# Section 55

## Acceptance of Applications Checklist

## East Midlands Gateway phase 2 Section 55 Acceptance of Applications Checklist

# Appendix 6d.2 – ES Link ID Locations Around Kegworth

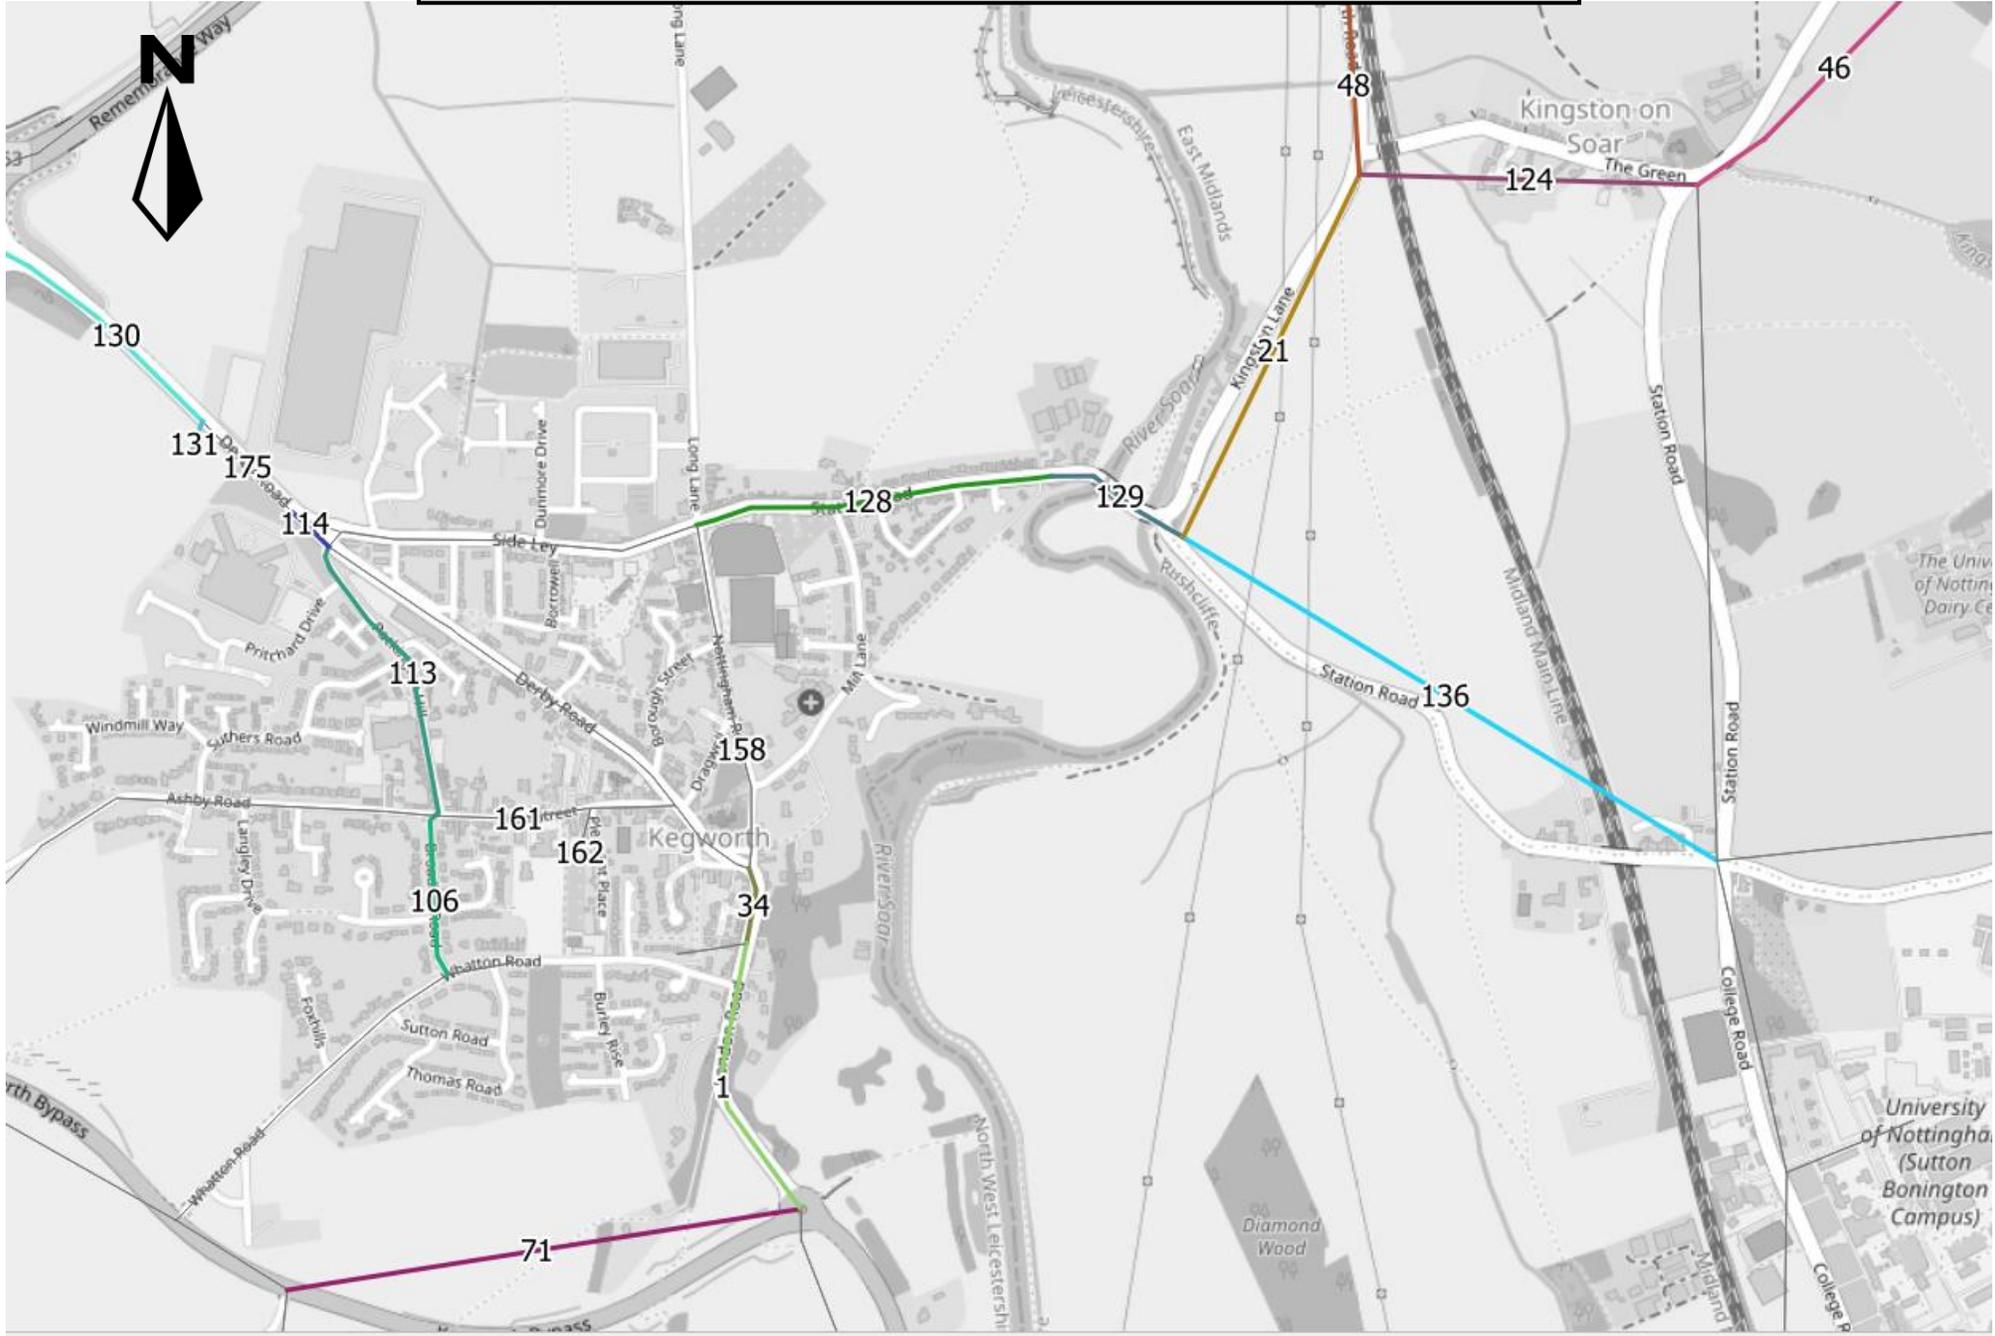
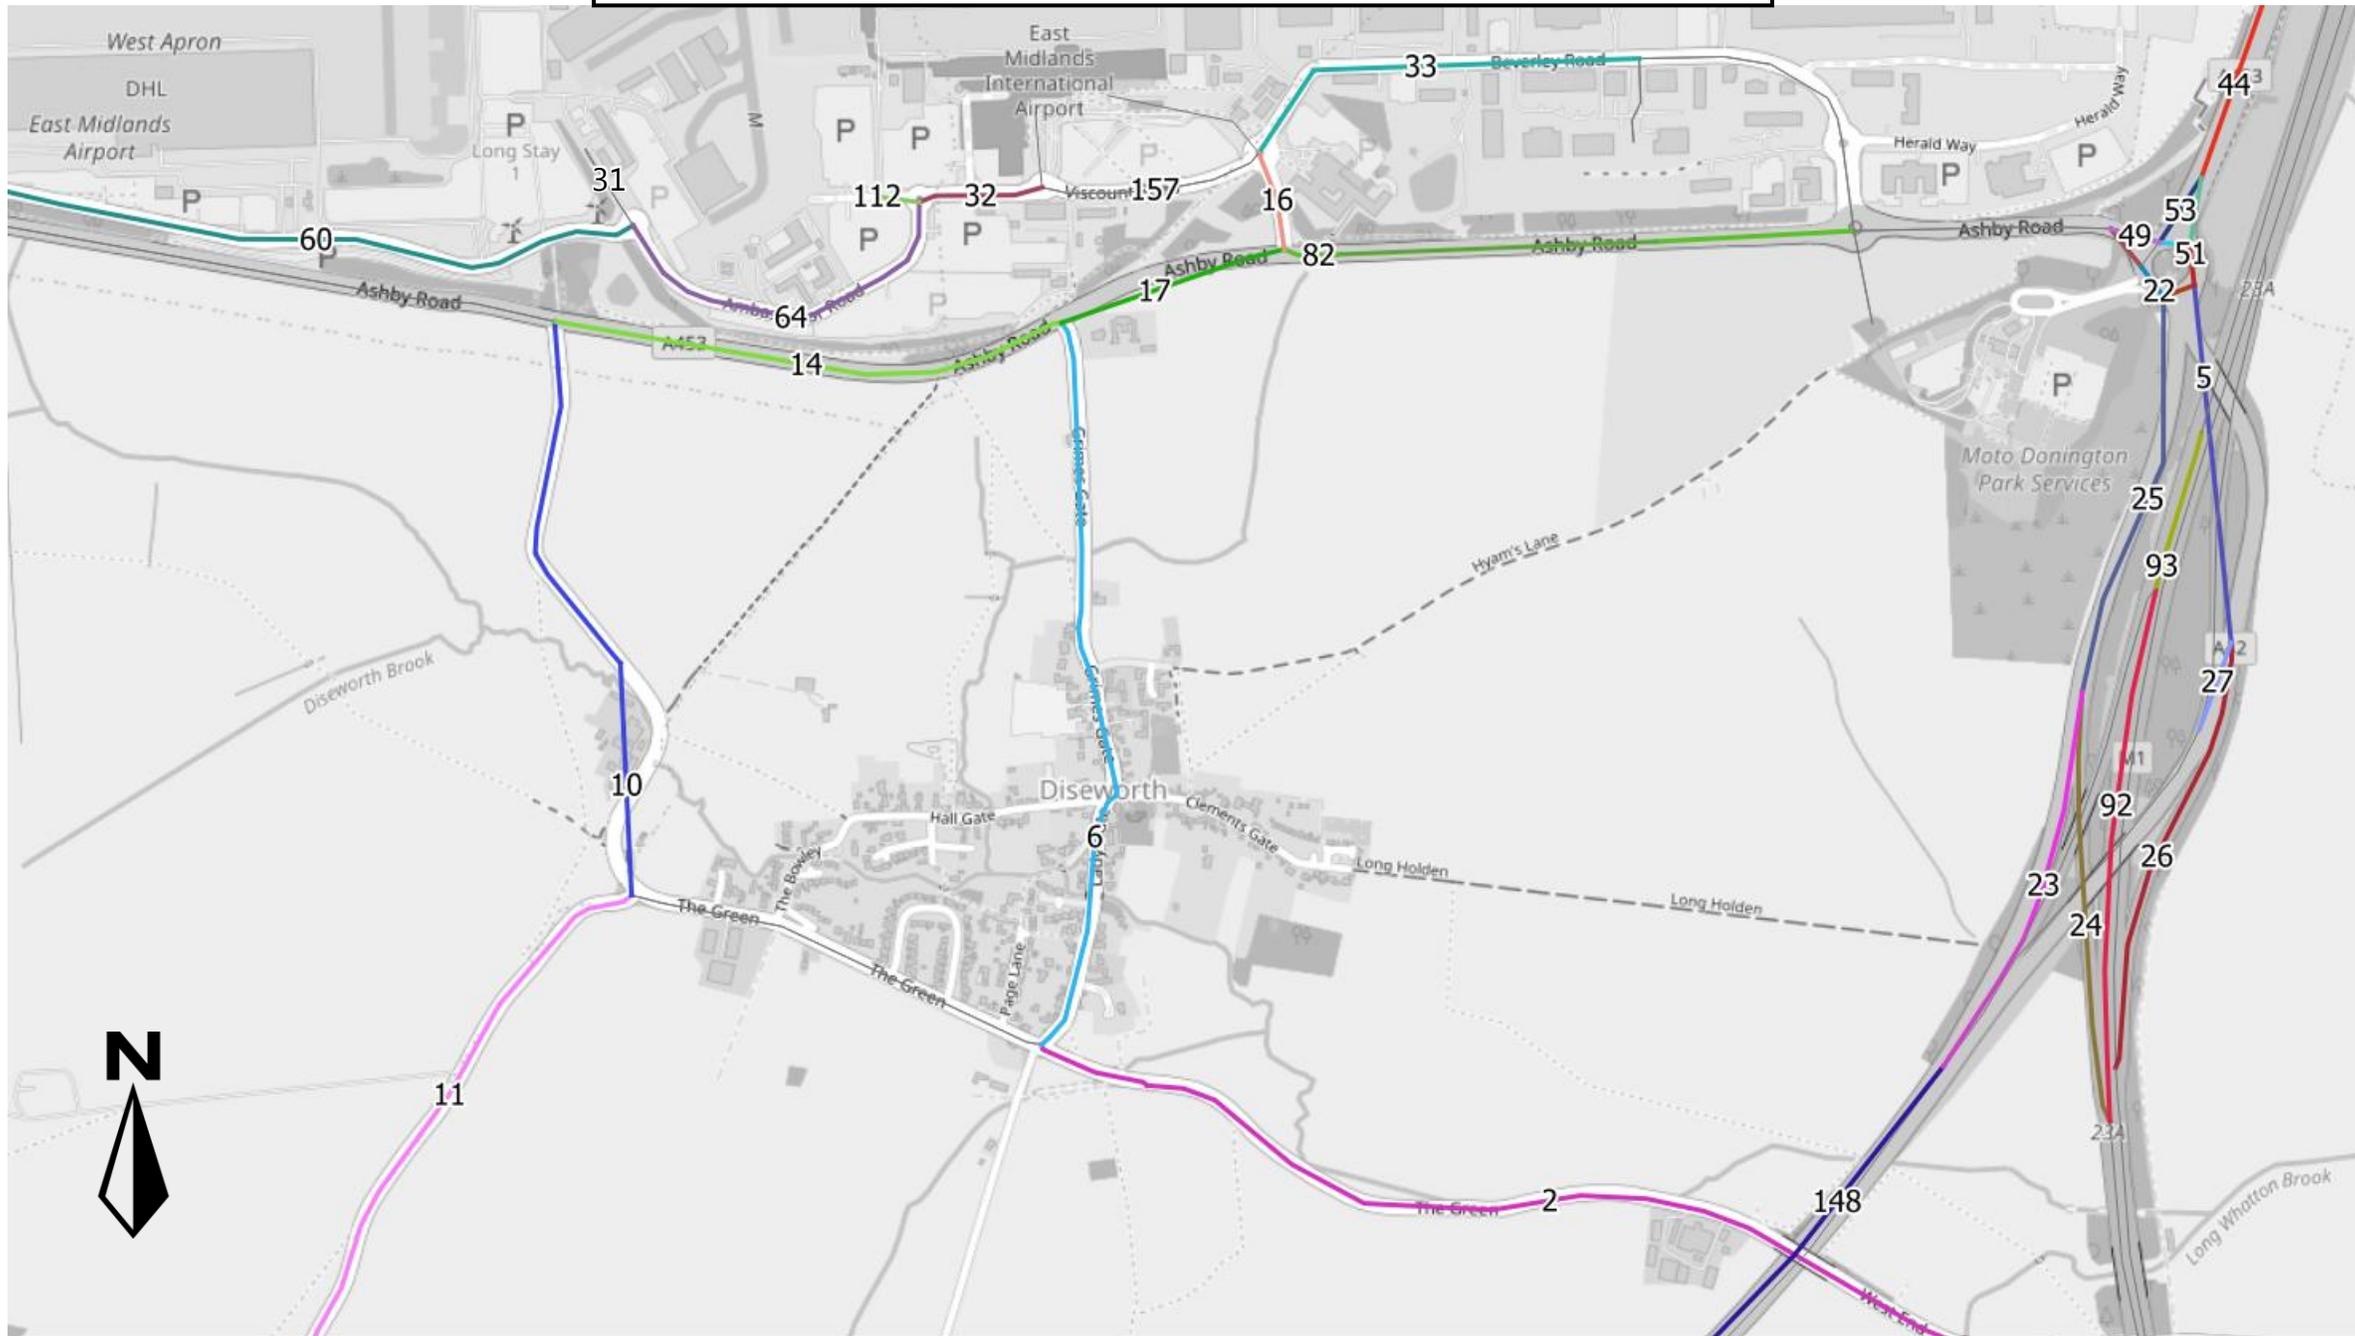
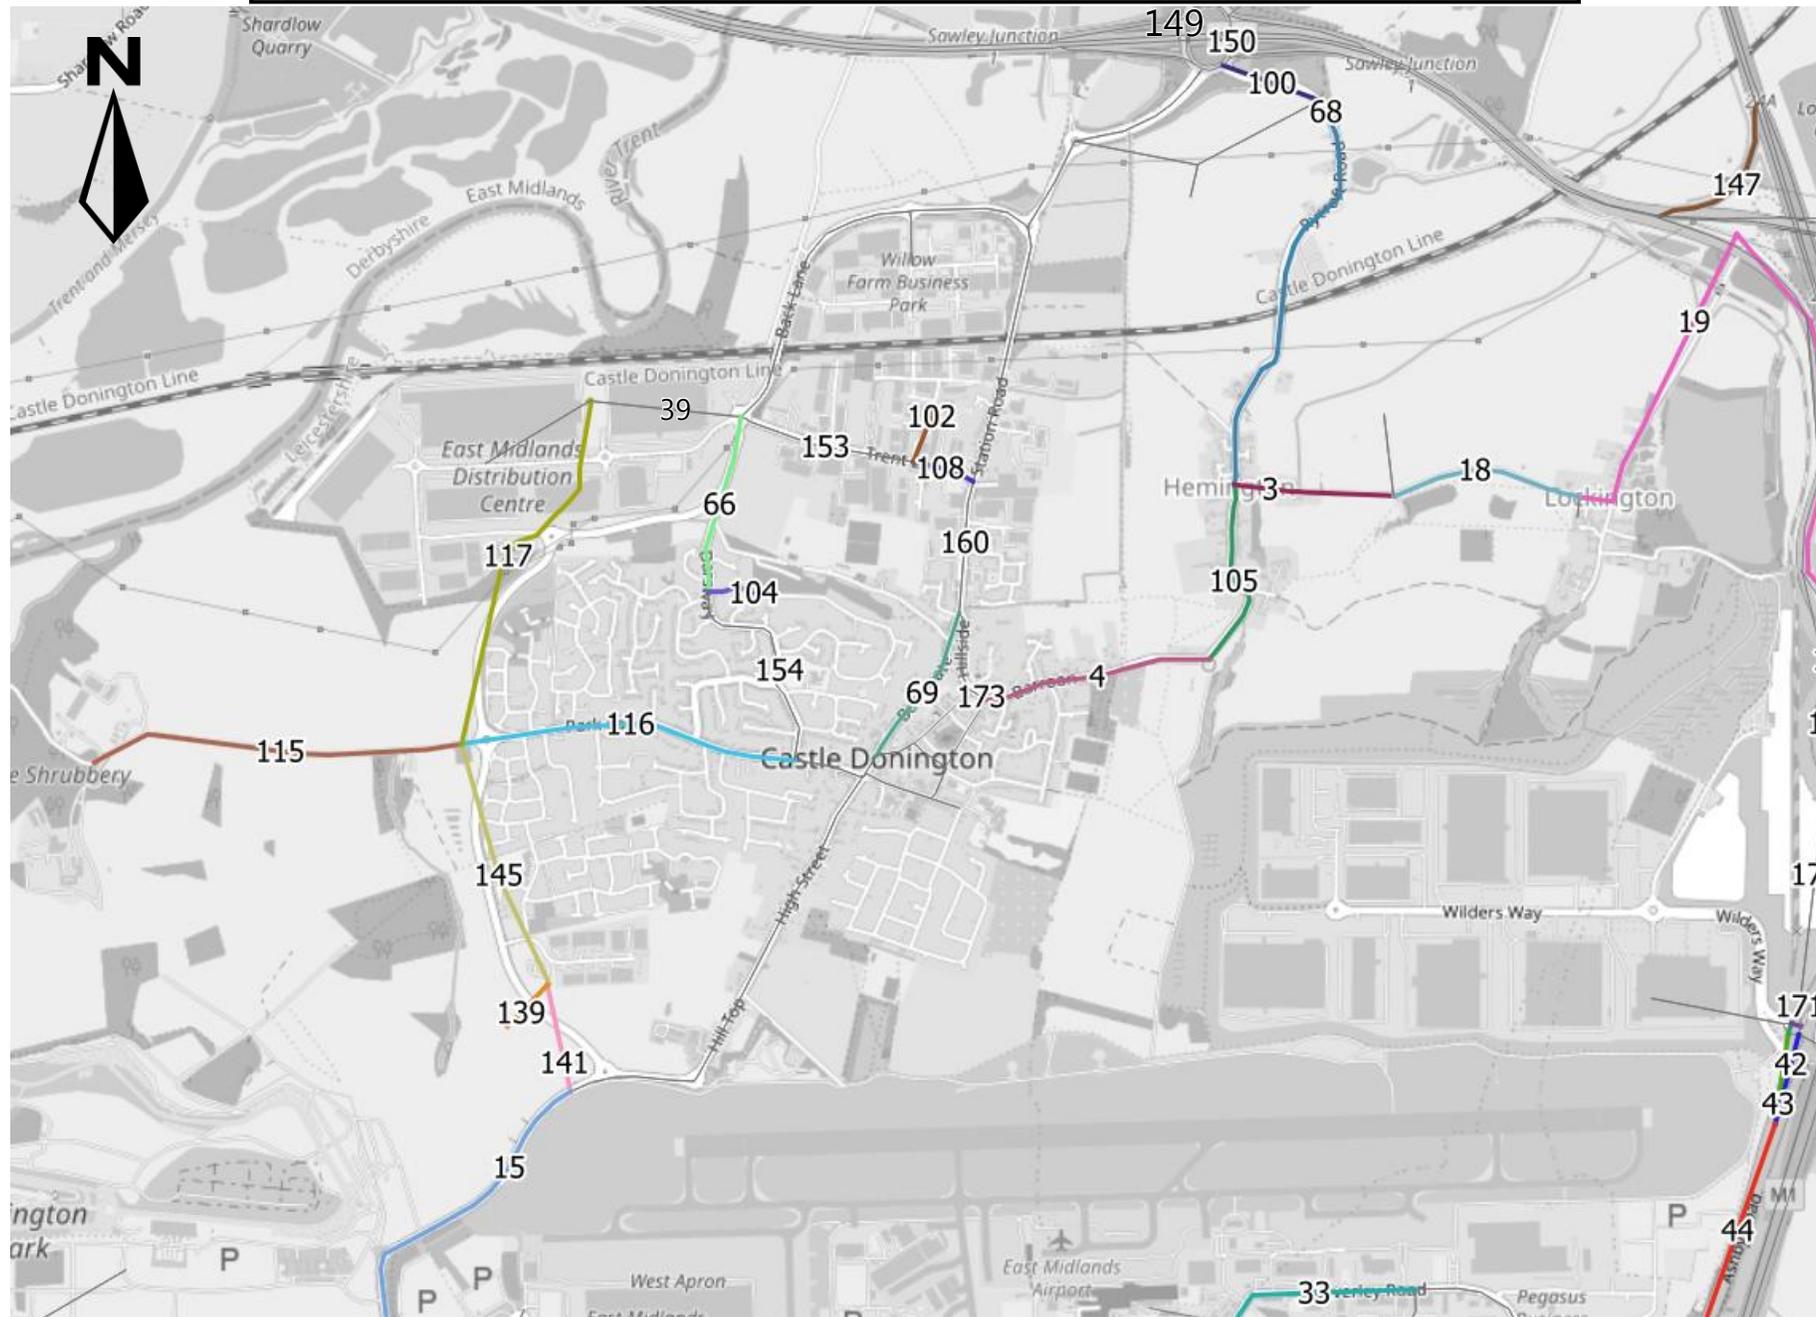
- i. The following links have been incorrectly identified either in the text of the ES Chapter 6 (tables 6.9 and 6.14) or appendix 6.6D:
  - 141 and 145 – which are said to be the Kegworth bypass but are shown in Castle Donnington
- ii. The following links have been numerated in tables 6.9 and 6.14 of ES Chapter 6, but the extents are either not shown at all or not clearly in appendix 6.6D:
  - 8, 29, 31, 34, 35, 37, 38, 39, 45, 47, 96, 97, 108, 126, 141, 149, 150, 151, 152, 153, 154, 155, 157, 158, 159, 160, 161, 162, 163, 164, 165, 166, 167, 168, 169, 170, 171, 172, 173, 174
